BLAKE POND COMMUNITY – All applicable lots

TOWNSEND MODEL – ELEVATION 1

REAR DECK BEAM

M+K Project #: 126-23061 (40/01)

IST FLOOR FRAMING PLAN SCALE: 1/8"=1'-0"

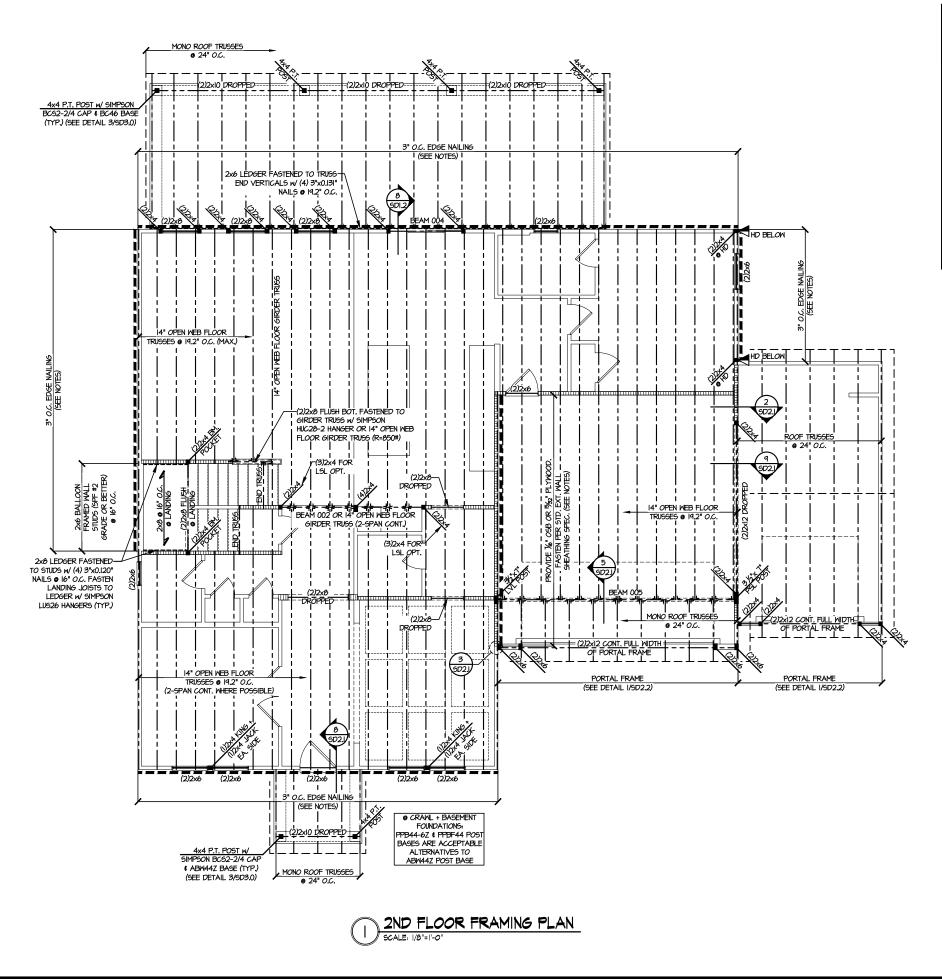
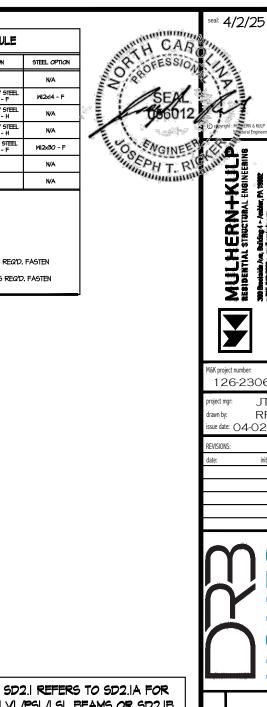
Pursuant to your request, we have prepared this letter to address the concerns of the building inspector for the above referenced lots. It was reported to us, by you, that the inspector is questioning the structural design of the rear (3)2X12 deck beam.

We have designed this beam for all code required loads and it is our professional opinion that this beam is structurally adequate and no repairs are required.
